Please ask for: Nicola Moore
Email: nicola.moore@arun.gov.uk
Telephone: Ext 37944
Our Ref: LU/371/21/PL
Your Ref:
Date: 23rd November 2021

Application for Planning Permission

Development: Variation of Condition following grant of LU/284/19/PL relating to Condition no 8 - integration of bat bricks, tiles or tubes.
Location: Holly Tree Cottage 1a Northway Road Littlehampton BN17 7JX

site & block plan tp782/09

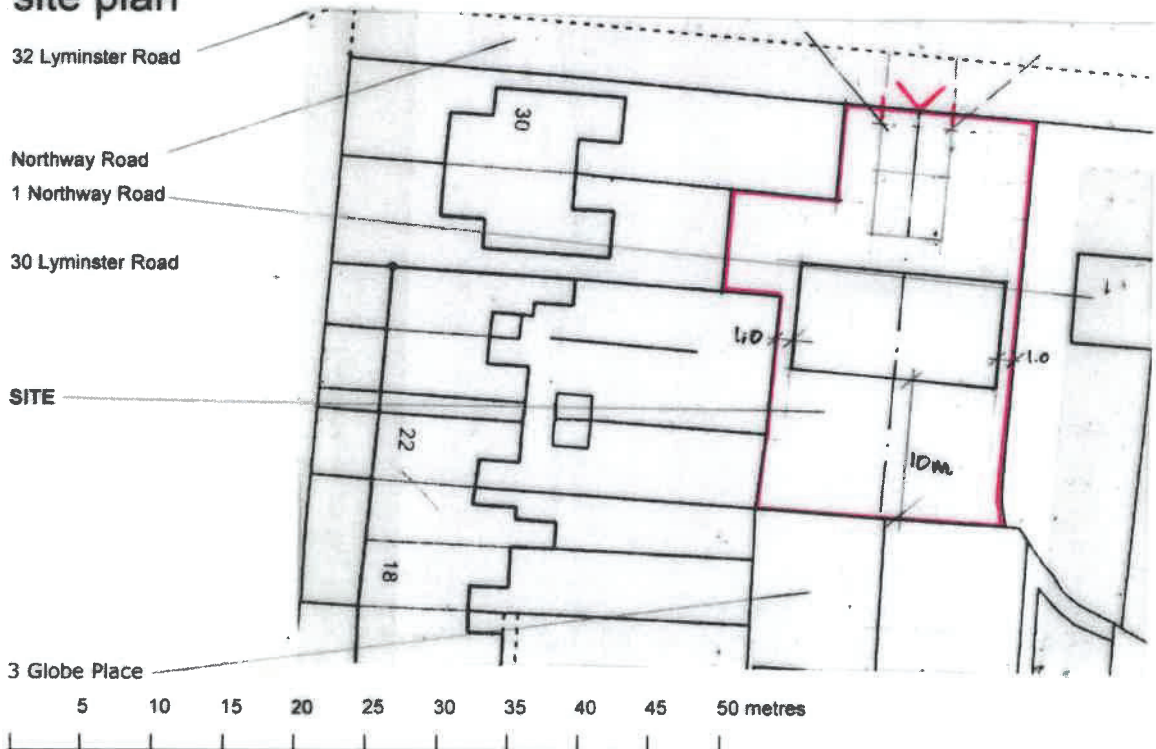
The submitted Location Plan/Block Plan does not scale correctly at 1:1250 and 1:500. Please re submit ensuring correct paper size/scale.
